From: Damian Sullivan
Sent: 03 September 2014 14:22
To: Planning.Responses
Subject: A/99/14/HH

**ADC Planning Consultation
Response from the Conservation Officer**

Application Number	A/99/14/HH
Address	Woodford Villas 2 High Street Angmering BN16 4AE
Description	Removal and reconstruction of part of the front boundary wall (resubmission following A/46/14/HH). This application affects the character and appearance of the Angmering Conservation Area.
Case Officer	Mr. D Sullivan

DRAWING TITLE
EXISTING FRONT BOUNDARY WALL
ELEVATIONS, PLAN AND SECTION

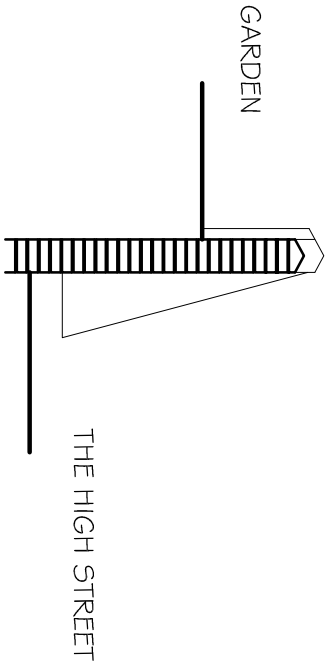
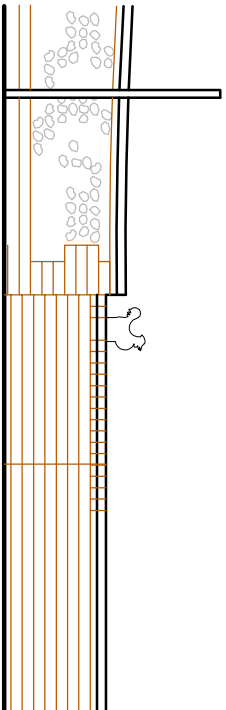
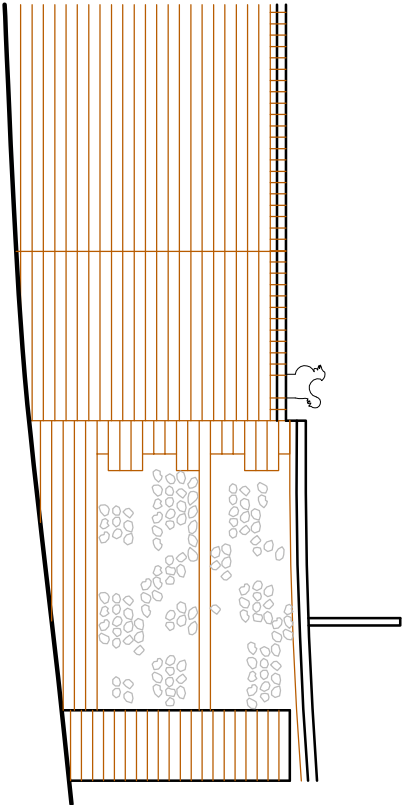
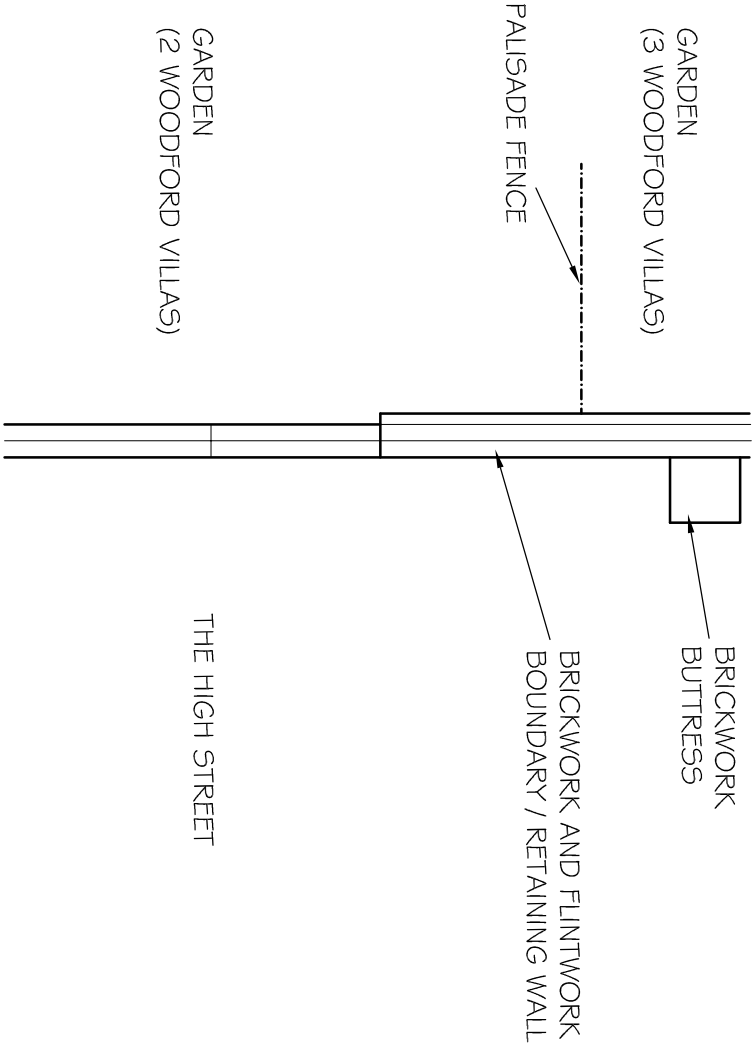
This proposal affects a pedestrian opening which provided access to a number of residential properties. The existing walling either side of the proposed new replacement section is constructed from two different materials; brick to the left hand side and brick/flint to the right. The walling plays a prominent part of the street-scene.

The existing section of walling to be removed fails to link in to the existing walling and appears almost as if an afterthought. This is evidenced by the distinctive joints between the existing and new sections of walling, and its removal is supported.

DRAWING TITLE
PROPOSED FRONT BOUNDARY WALL
ELEVATIONS, PLAN AND SECTION

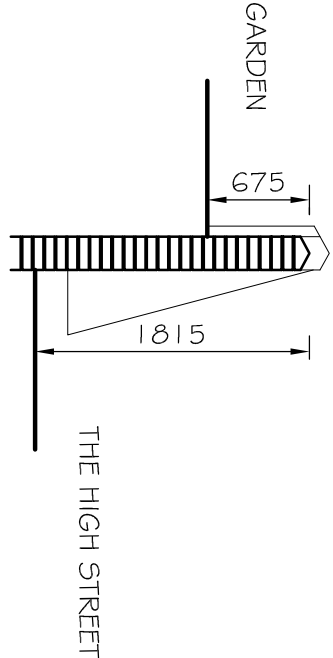
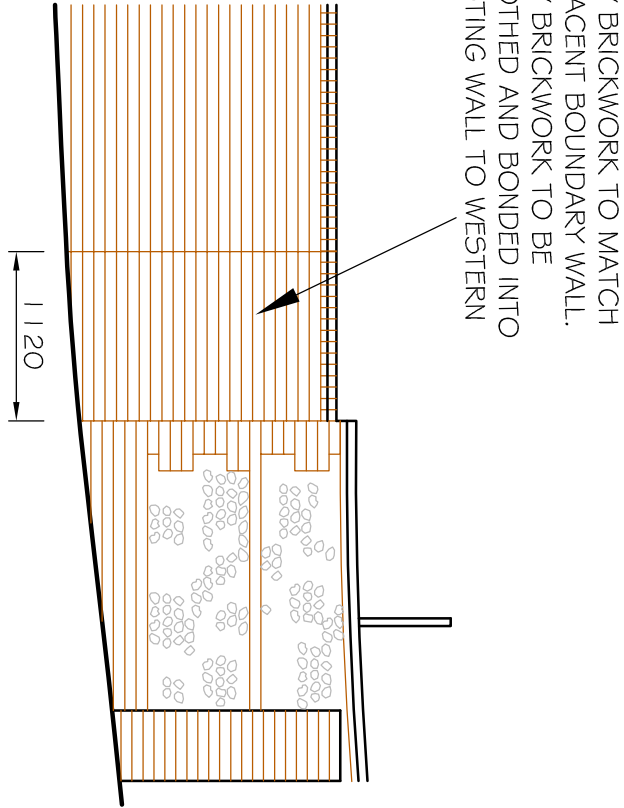
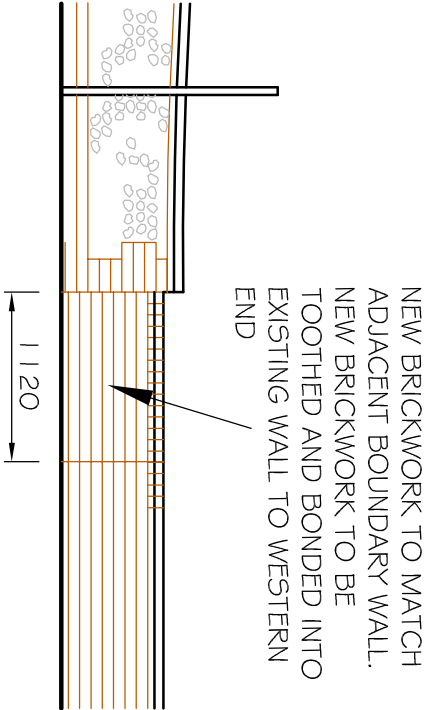
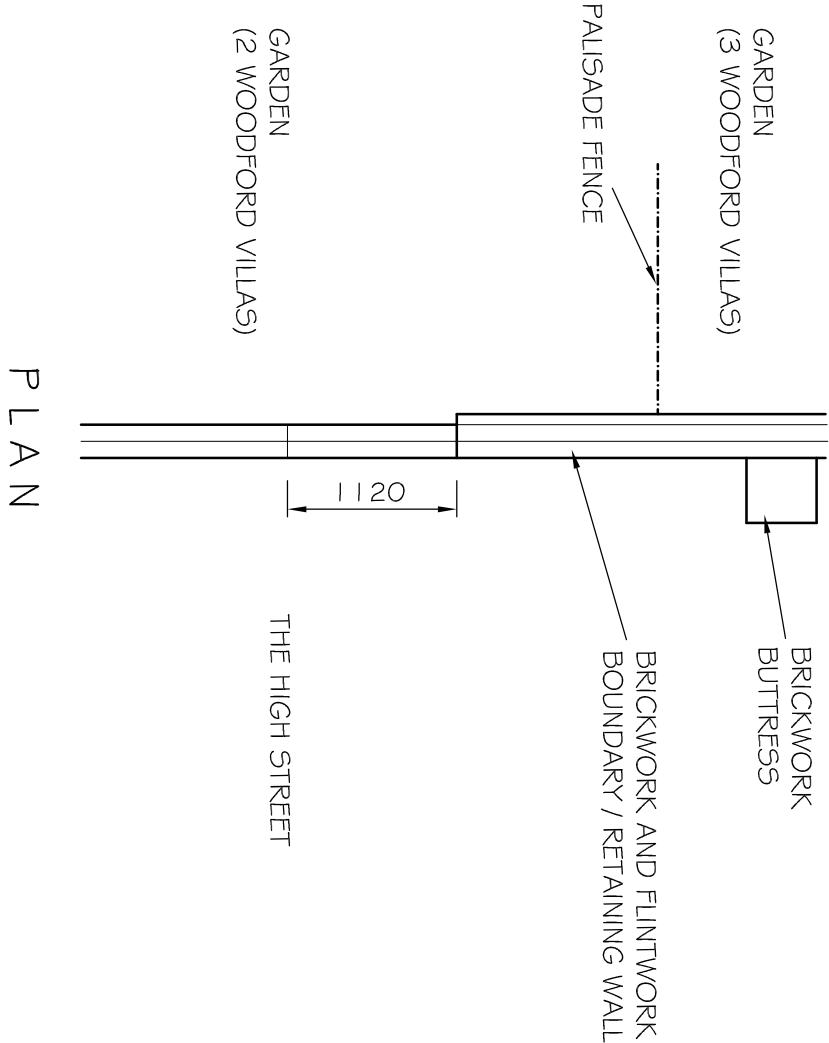
The current proposal aims to deal with this concern by linking the new section of walling into the existing brick wall structure. This will require a skilled craftsman to ensure that the works respect the wall, and not harm it.

Further, the access point provided a link, through the provision of lines of sight, to the properties behind, as well as what I believe were attractive steps.

In light of this, it is considered unfortunate for the opening to be permanently in-filled. An alternative, more acceptable approach could be to close the opening with a gate or similar means of enclosure to enable the views through to the space beyond to remain.
